Date: 05 March 2019
Our ref: 273538
Your ref: EN010084

Natural England have provided comments on the following documents at Deadline 3:

1. Saltmarsh Mitigation, Reinstatement and Monitoring Plan (SMRMP) (Revision B)

**Figure 4.2: Theoretical Survey Area and *S. spinulosa* Reef Extents**

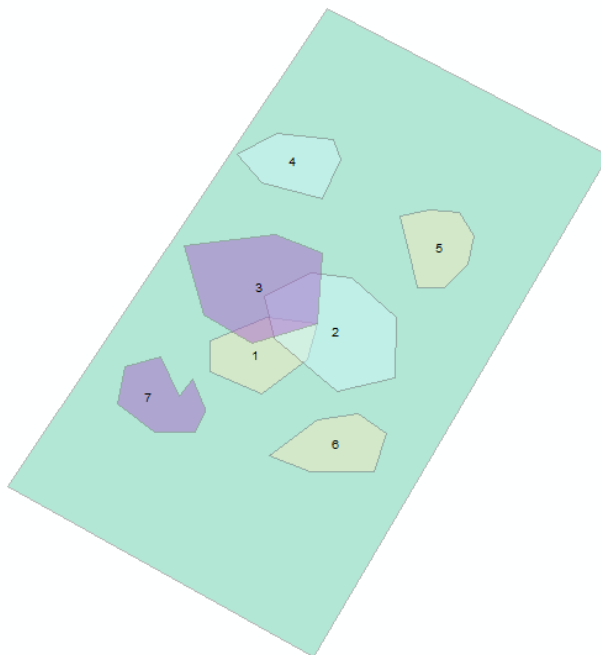
MCZ Assessment Clarification Note		
Point	Section	Comment
1.	11	Considering the ephemeral nature of <i>Sabellaria</i> and the fact data was collected in 2014 for the MCZ characterisation data, by the time construction is due to take place this feature could have colonised this area. The biogenic reef plan and pre-construction surveys with the potential for ground truthing, if this feature is identified, would further the understanding of the cabling area. However, these ground truthed points for biogenic reef to be replicated post construction to determine any impacts.
